## PLAN EXAMINATION CONDITIONAL APPROVAL

**PROJECT/SITE DESCRIPTION:**  
Maine Medical – Visitor’s Garage Extension

**PROJECT ADDRESS:**  
22 Bramhall St – Portland, Maine

Review Type:	All Trades
Plans Date:	3/30/18
# of Sheets:	96
Project Area (sq. ft.):	82,201

1 FIRE PROTECTION RISER DIAGRAM
SCALE: NTS

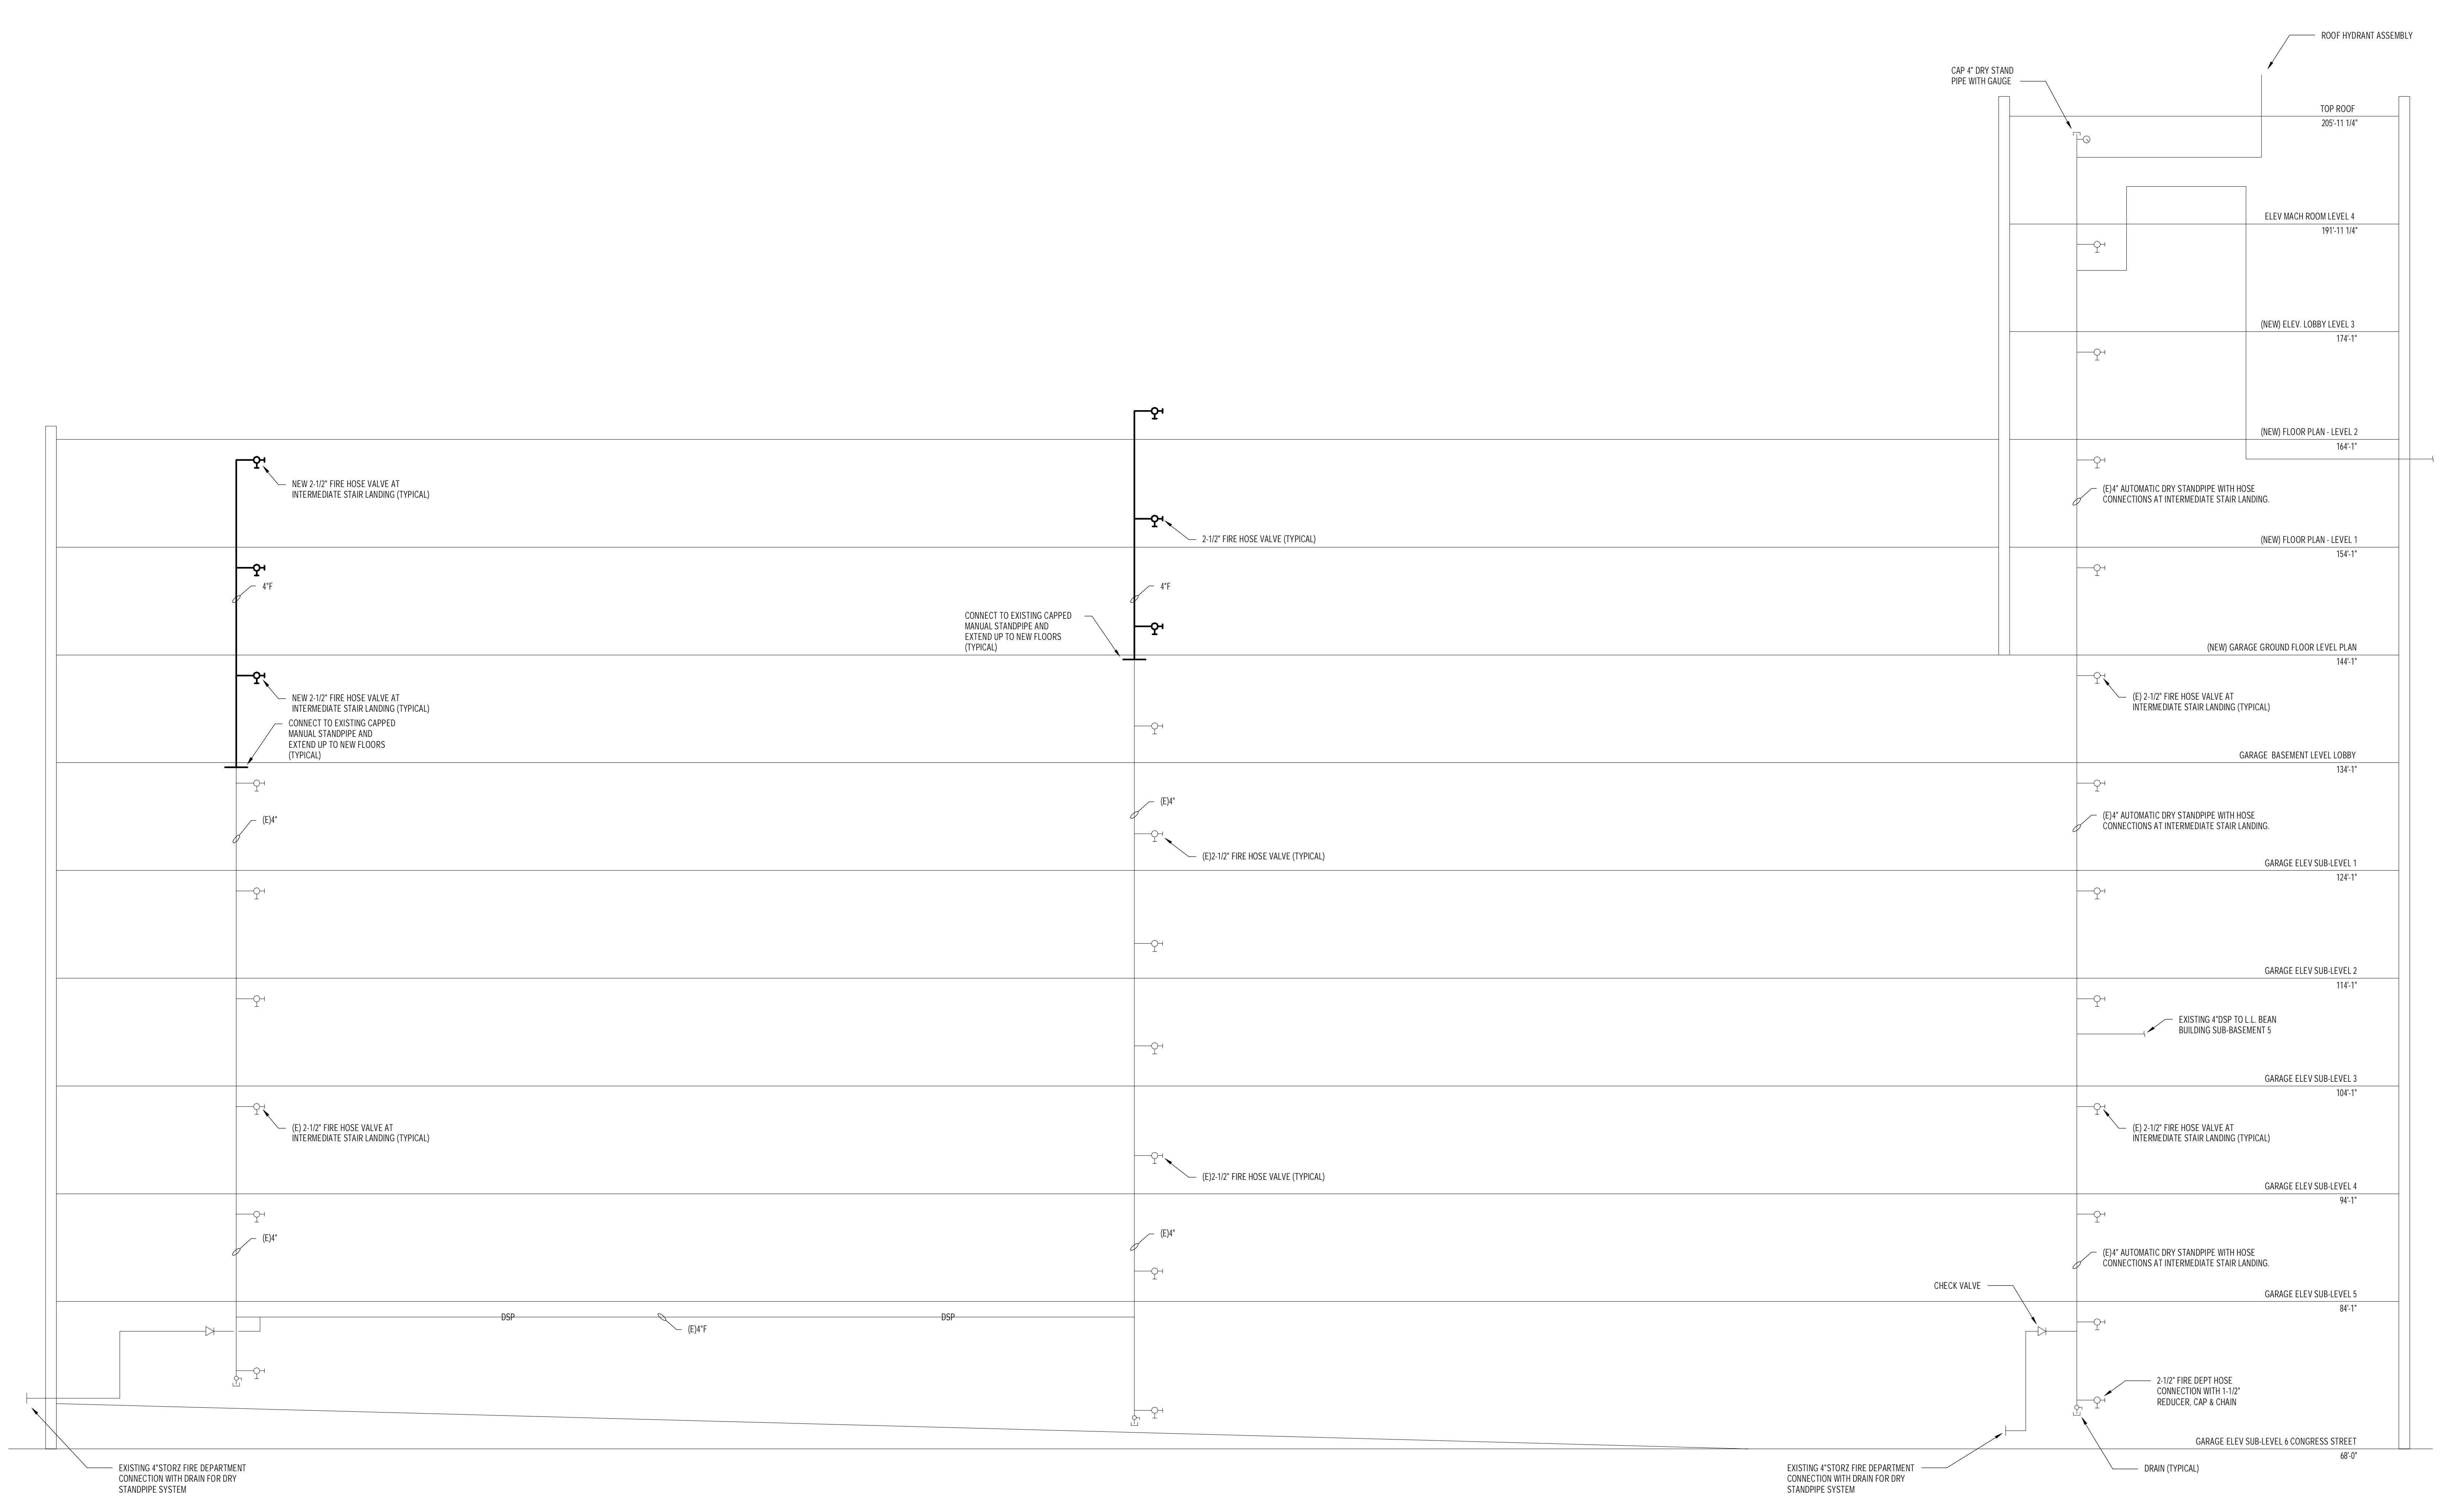
1. There is a discrepancy on the fire protection riser size. Sheet F00-10 & F10-10. Clarification needed.
2. Complete information regarding the fire protection system(s) shall be submitted to indicate conformance to applicable codes and regulations. The construction documents shall be approved prior to the start of system installation. Shop drawings shall contain all information as outlined in Chapter 9 of the Maine Building Code, NFPA 1 and NFPA 13. (IFC Figure 903.3)
3. Valves controlling water supplies shall be electronically supervised in accordance with the Maine Building Code (with exceptions) NOTE: Fire alarm plans have been submitted for review and do not indicate supervision. Please clarify.
